**CITY OF ALBUQUERQUE
Planning Department
November 14, 2007
DRB Comments
2nd Set**

PROJECT #1006922

RE: Lot 27-A/spbp....second set of comments

RE: Lot 27-A/spbp & minor plat

PLAT OF  
**LOT 27-A**  
 BLOCK 9, TRACT A, UNIT B  
 NORTH ALBUQUERQUE ACRES SUBDIVISION  
 SITUATE WITHIN  
 PROJECTED SECTION 13  
 T.11N., R.3E., N.M.P.M.  
 ELENA GALLEGOS LAND GRANT  
 CITY OF ALBUQUERQUE  
 BERNALILLO COUNTY, NEW MEXICO  
 NOVEMBER 2007

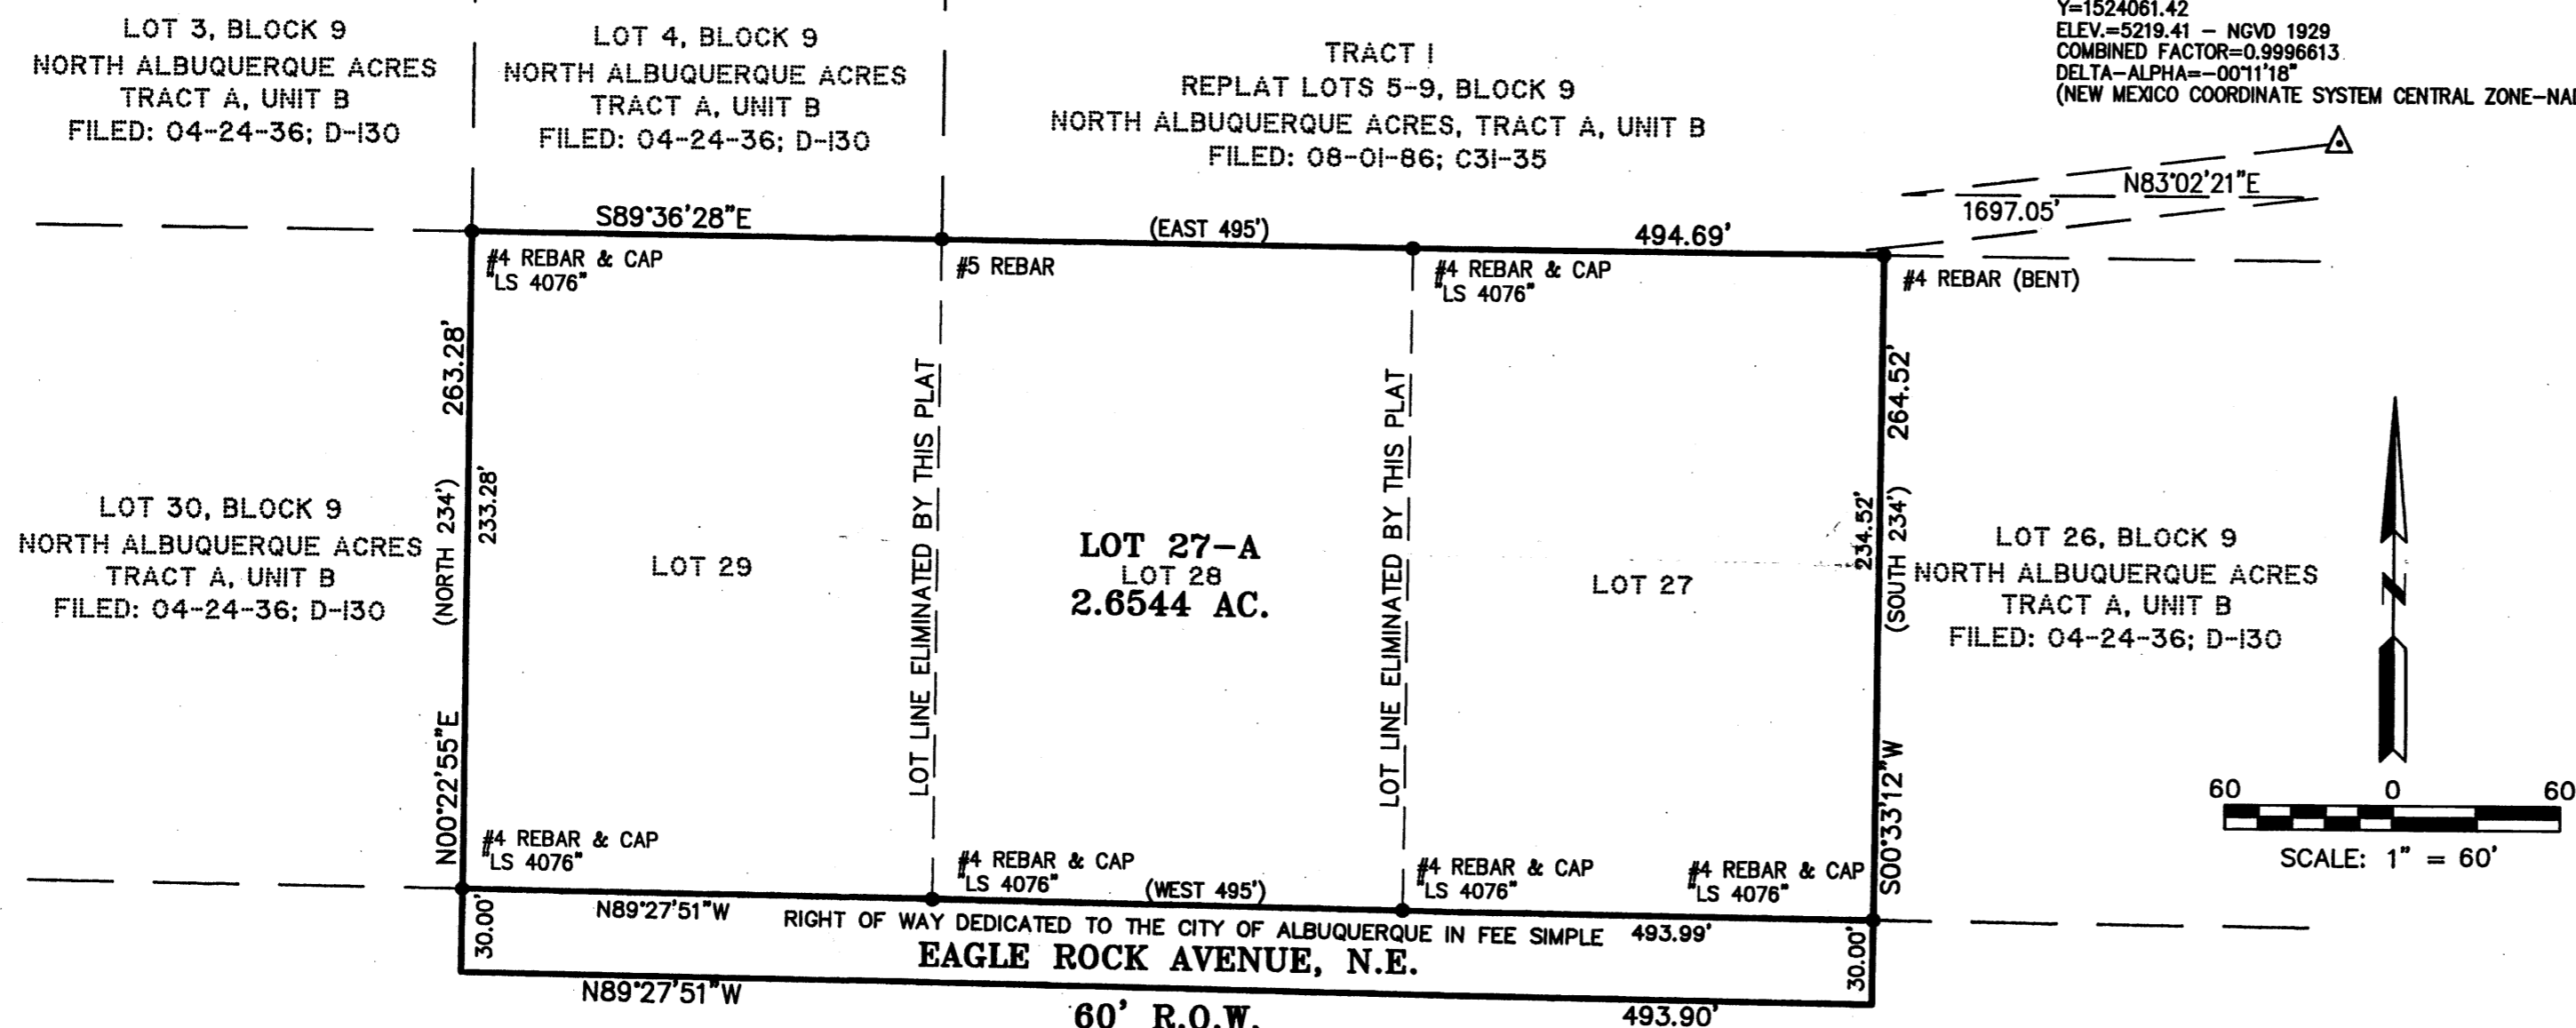
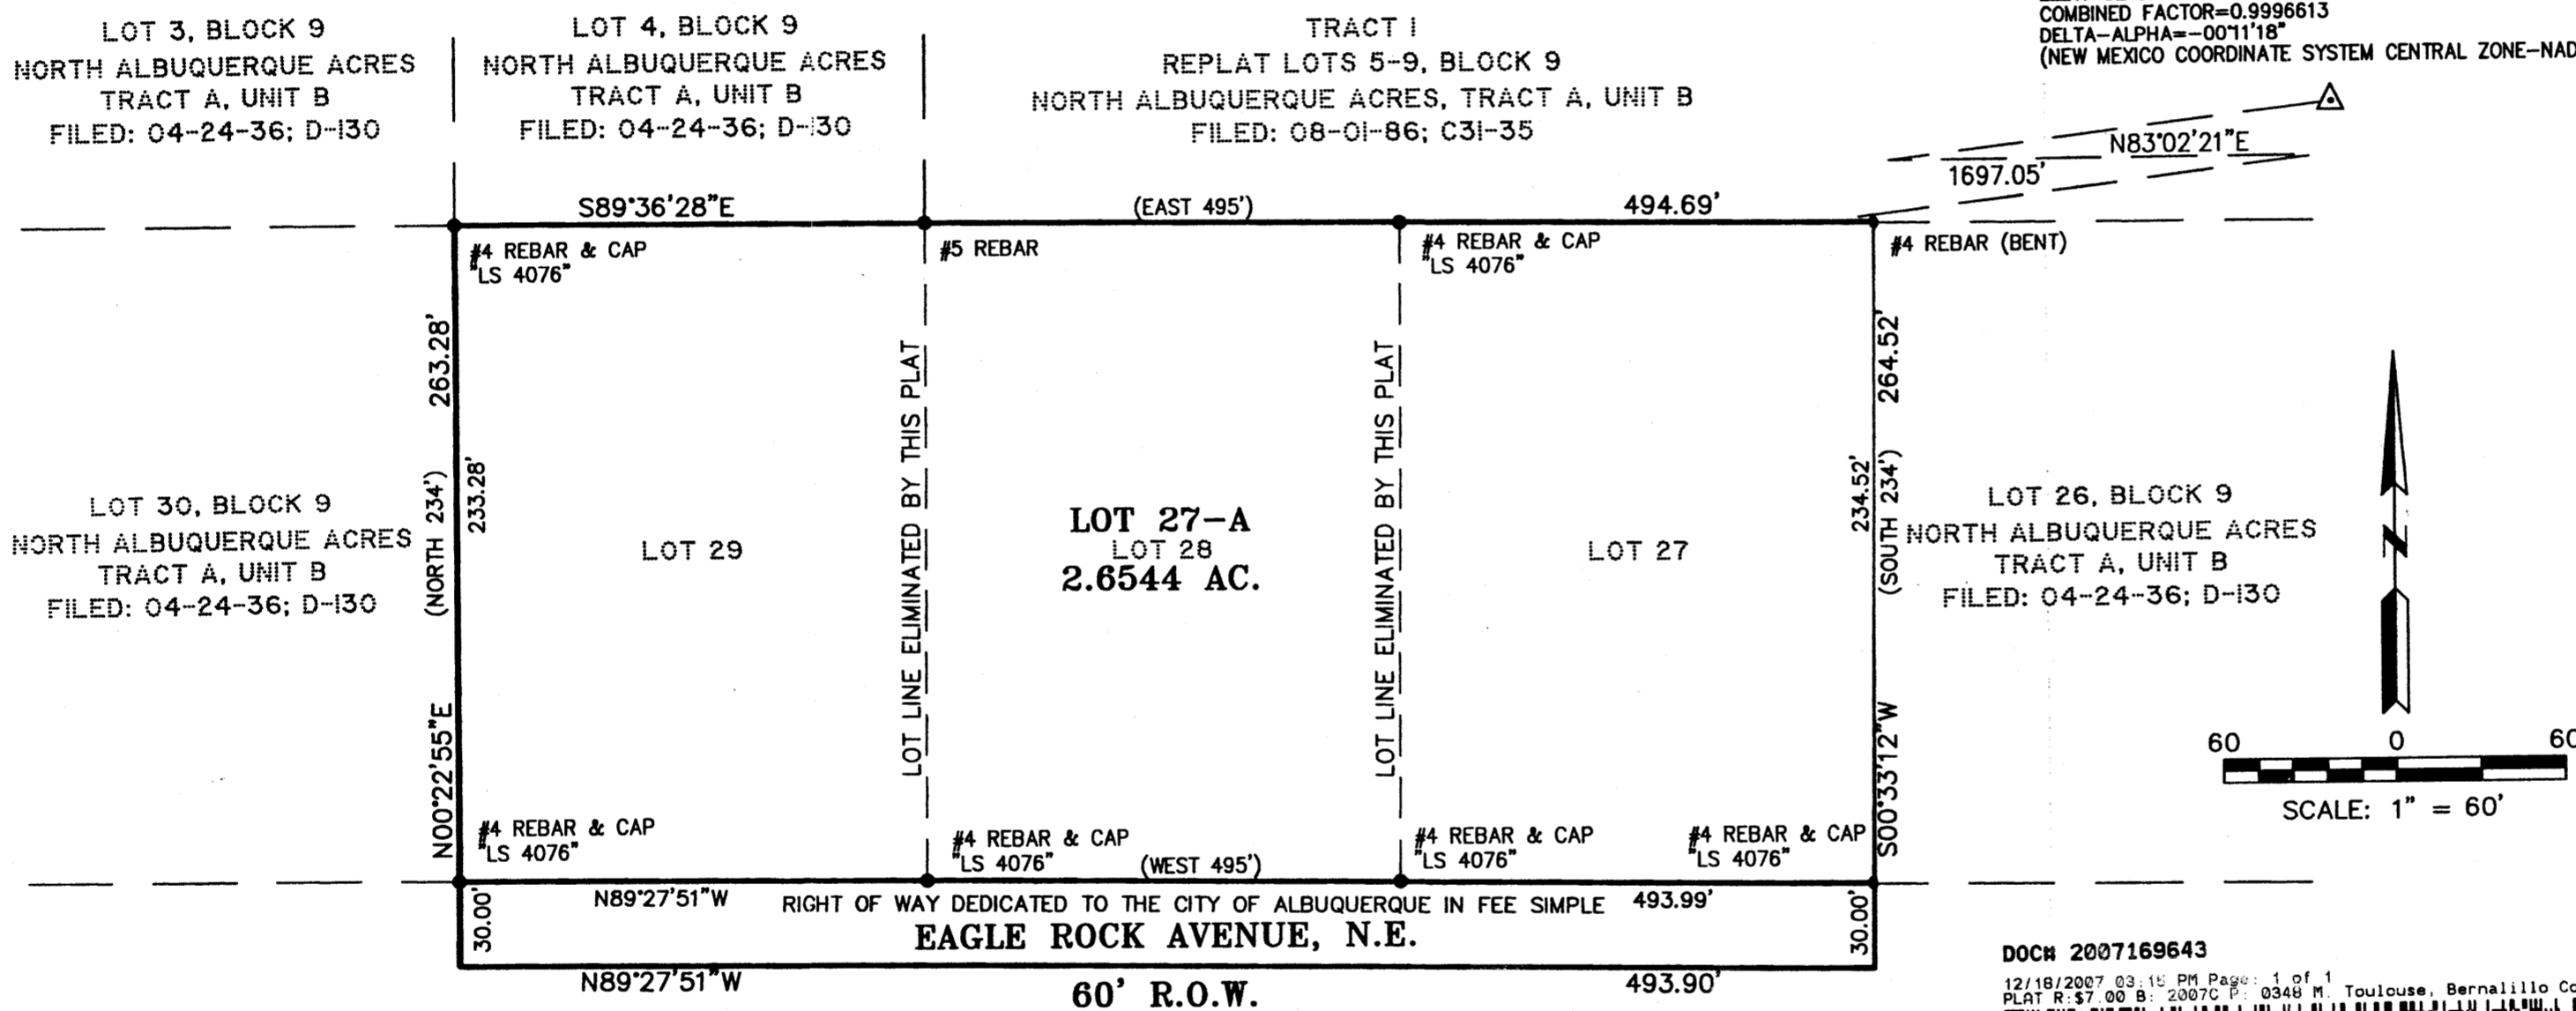
1. The plat matches the site plan. However, it's missing the required solar collector language. AGIS dxf approval is not yet in the file.
